2025/0902

Change of use from a residential dwelling (C3) to a four bedroom HMO (C4) (retrospective).

PROPOSED FLOOR PLAN 1:50@A2

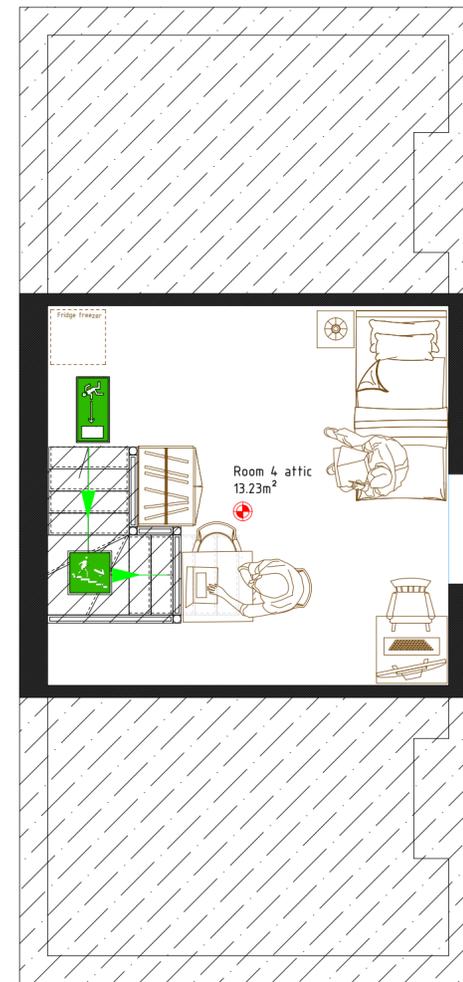
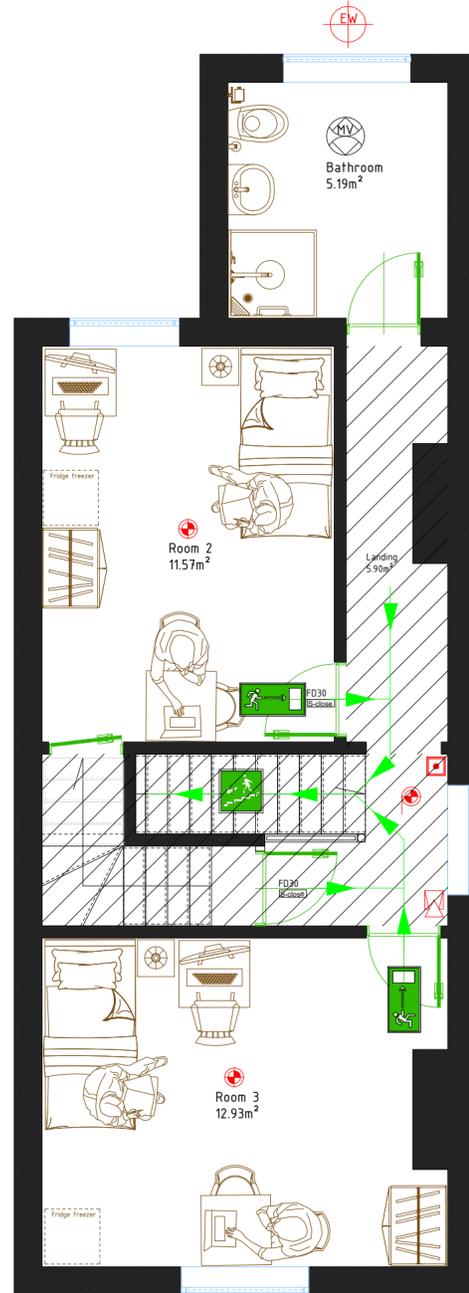
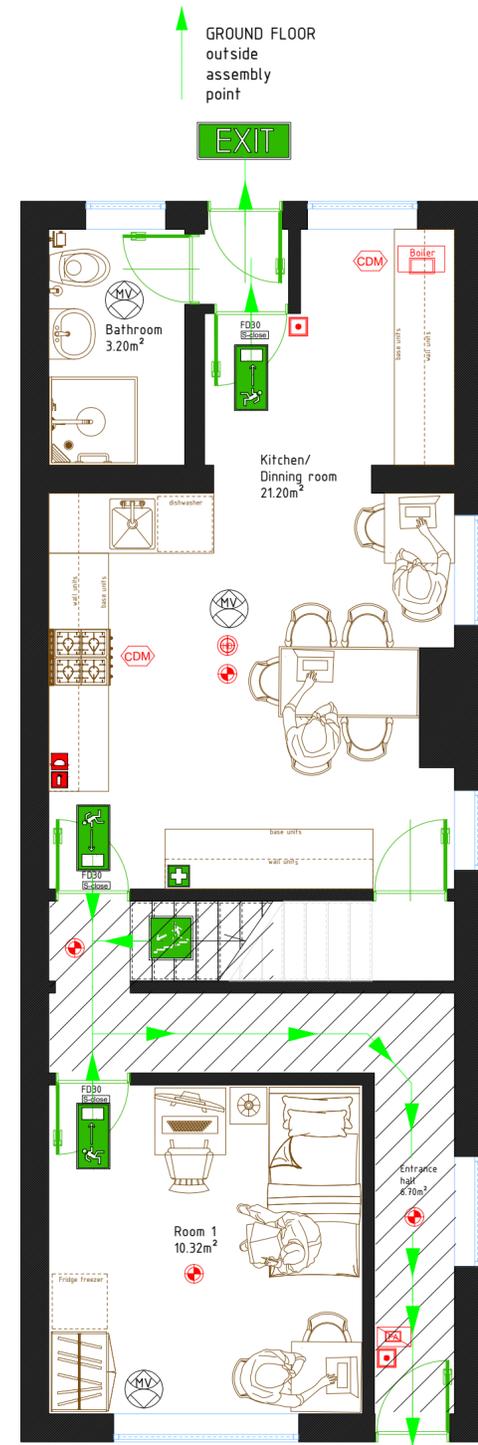
The application is seeking permission for the change of use of the property to a four bedroom HMO, the proposal is retrospective and the floor plans are shown below. It should be noted that the Councils Case Management Officer has noted that the floor plans do not reflect the current layout of the properties. The discrepancies are as follows:

- The only entry/exit for tenants of rooms 2,3 and 4 is via the back door, directly off the kitchen.
- The entry door for room 1 is located at the bottom of the staircase and has sole access of the front door as it forms part of the bedroom.
- The fire escape corridor to the front door is not in existence and forms part of room 1.
- The bathroom indicated on the first floor is a communal living room and not a bathroom

Although this application is retrospective, the submitted floor plans do not accurately reflect the existing property layout, as confirmed by the Case Management Officer. Nevertheless, the assessment must be based on the proposed plans as submitted.

The plans indicate the property would be configured as four individual bedrooms, one on the ground floor, two on the first floor, and one within the attic space. Two communal bathrooms are proposed, along with a shared kitchen/dining area; however, there is no provision for a shared living room or lounge. The SPD specifies that each HMO should include both a shared lounge and dining room, and that garden sizes should meet the general criteria for dwellings (i.e., a minimum of 60 square metres). It further requires that amenity space, internal and external spacing standards, and separation distances comply with these general criteria.

In this case, whilst the bedroom sizes are of a sufficient size, there is no additional communal living space for residents and no external garden provision. Consequently, the proposal fails to meet the SPD requirements and is considered likely to result in harm to the residential amenity of current and future occupiers due to inadequate space and poor living standards. The proposal therefore does not accord with Policy GD1 of the Local Plan.
